**WELWYN HATFIELD BOROUGH COUNCIL
EXECUTIVE DIRECTOR - PLANNING, PUBLIC PROTECTION AND GOVERNANCE**

DELEGATED APPLICATION

Application No: 6/2019/2313/FULL
Location: 101 Brookmans Avenue, Brookmans Park, Hatfield, AL9 7QG
Proposal: Erection of six dwellings following demolition of existing buildings
Officer: Mr David Elmore

LEAD SHOOT BELOW RIDGE
(X 3 EACH SIDE)
RIDGE TO BE
CONTINUOUS
OVER

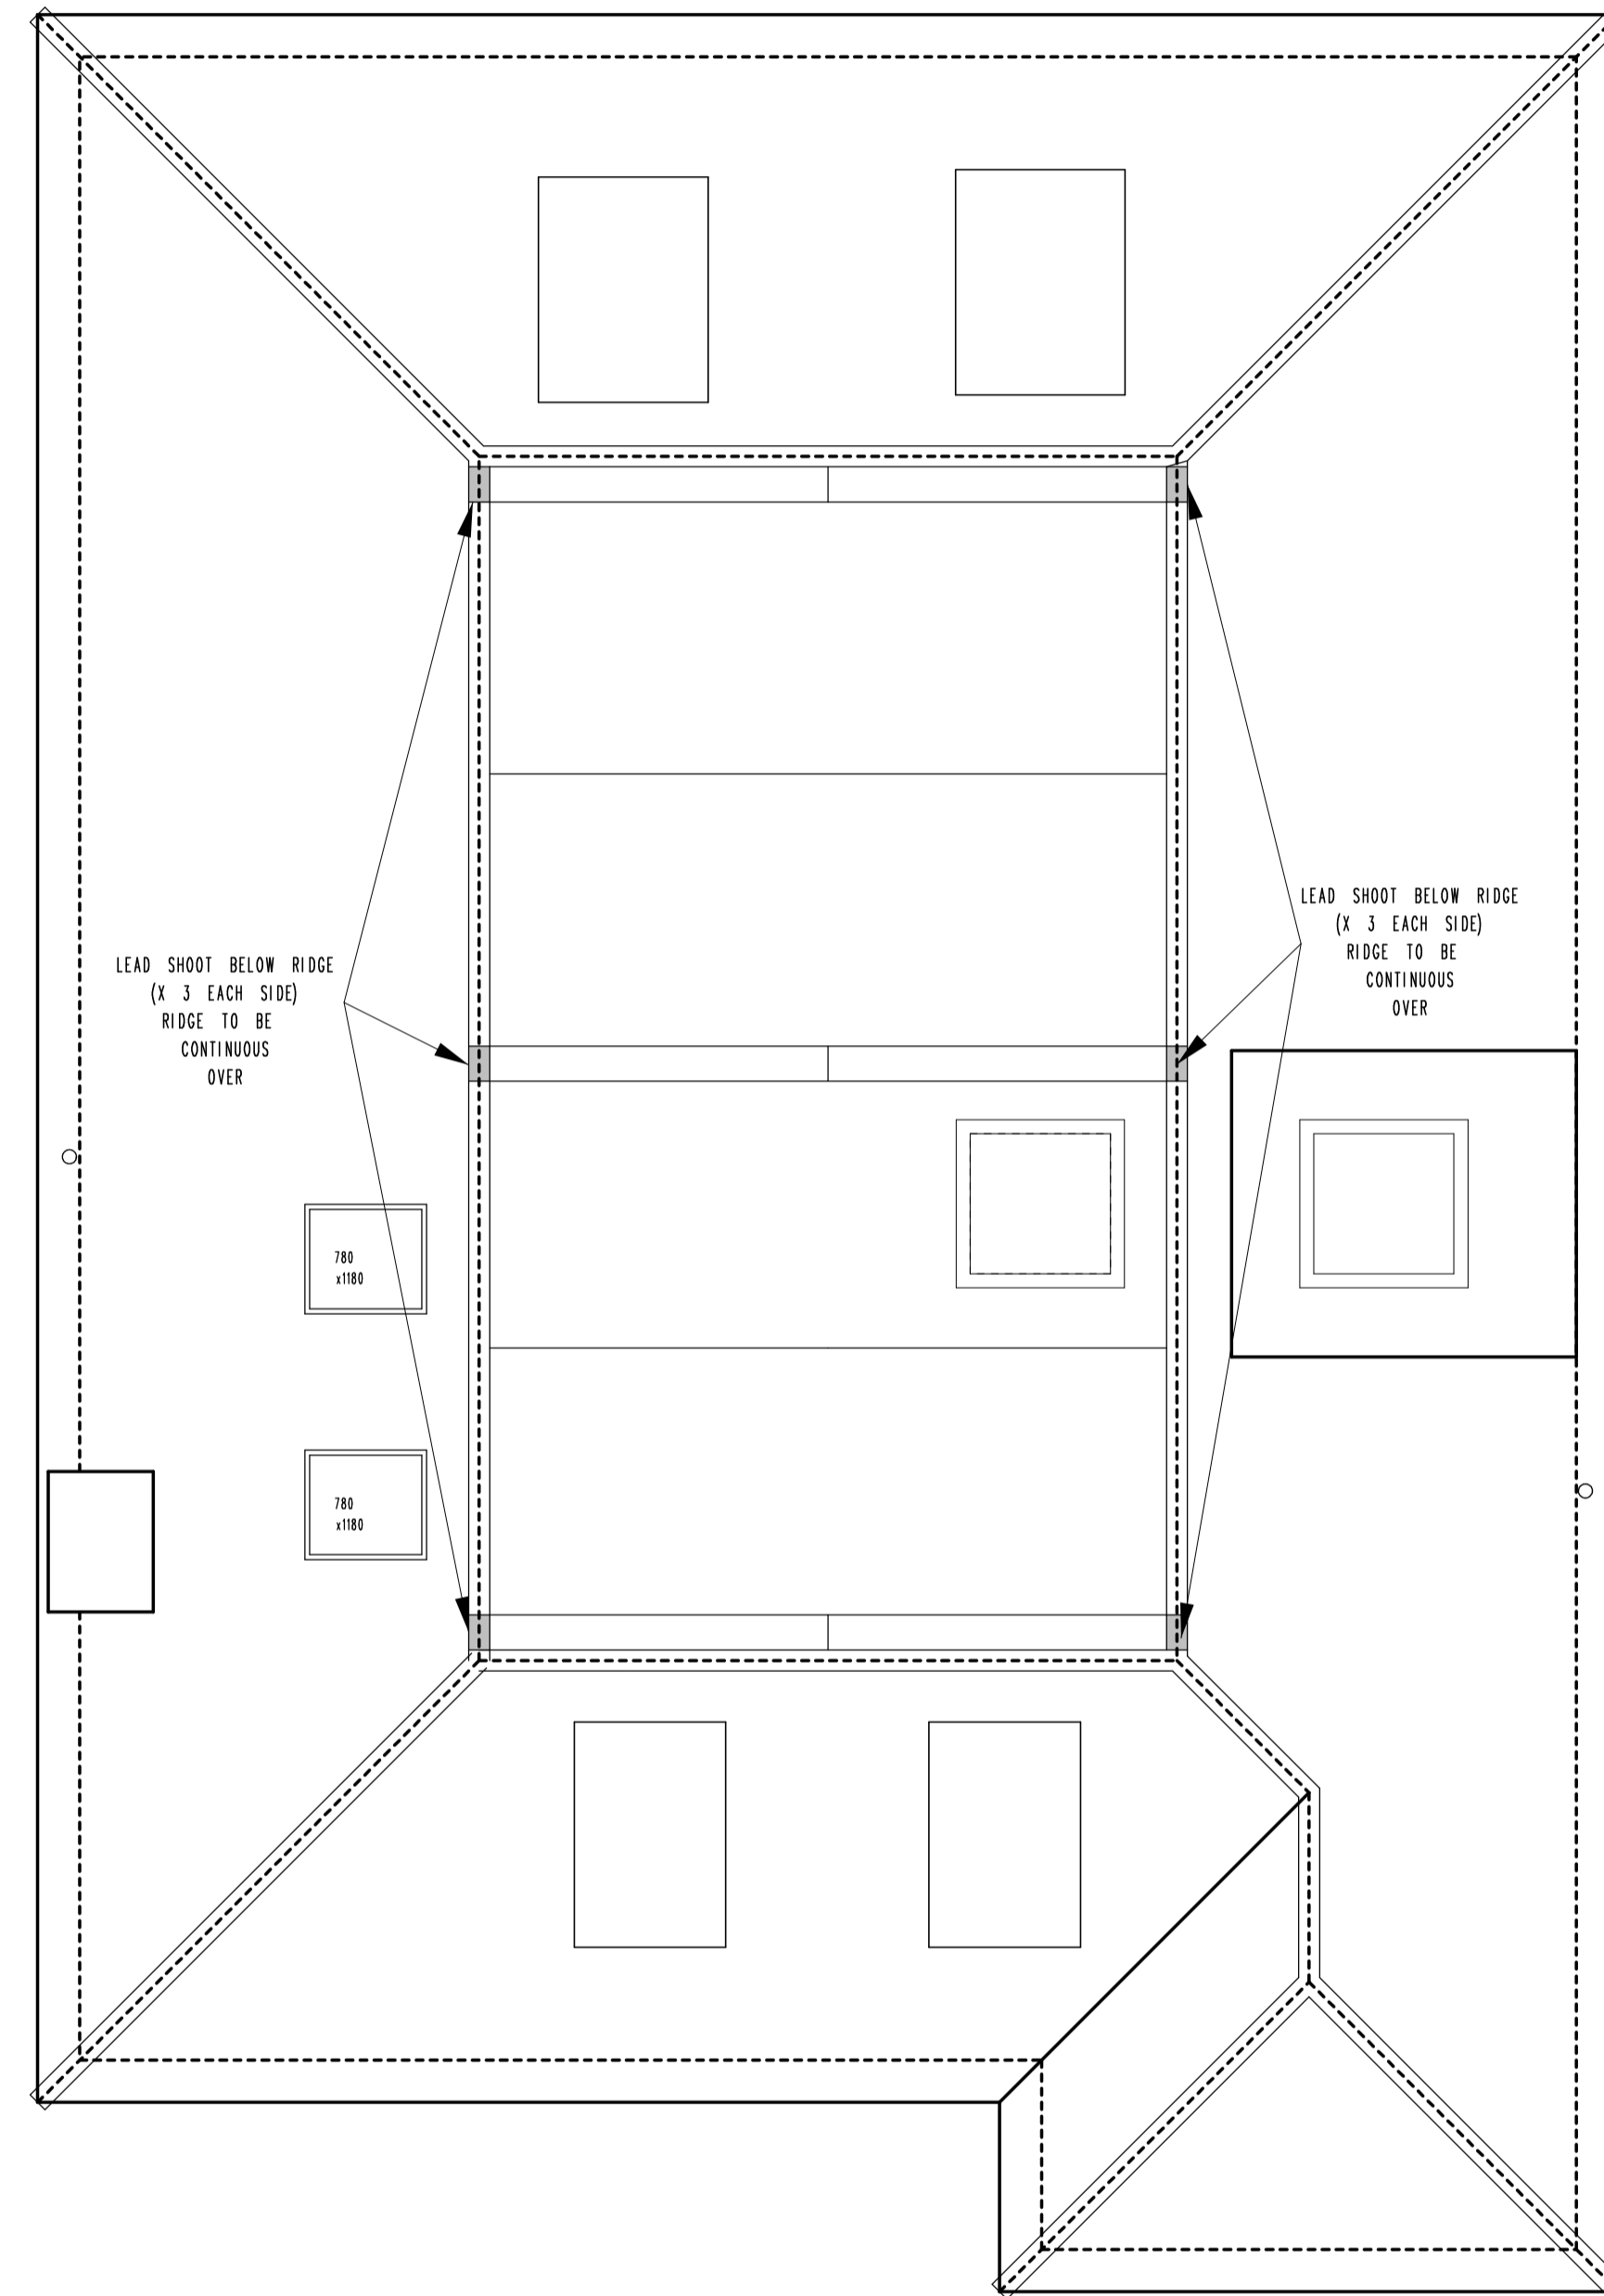
A drawing showing crown roof detailing has been submitted with this application. However, these details do not clearly show that the flat roof would be stepped down behind the surrounding pitched roof, nor does the drawing state that such detailing would be applied to each of the 6no dwellings proposed. Amended details can be secured through a planning condition.

1. Notwithstanding submitted drawing number: 48 5018-26, relating to crown roof details, no development above ground level shall take place until amended details of the proposed crown roof have been submitted to and approved in writing by the Local Planning Authority. The details, including; a roof plan, elevations and sections, in either 1:50 or 1:100 scale, and applying to all dwellings, must clearly show that the flat roof is stepped down and concealed behind the surrounding pitched roof. The pitched roof must use ridge tiles. Subsequently the development must be carried out in accordance with the approved details.
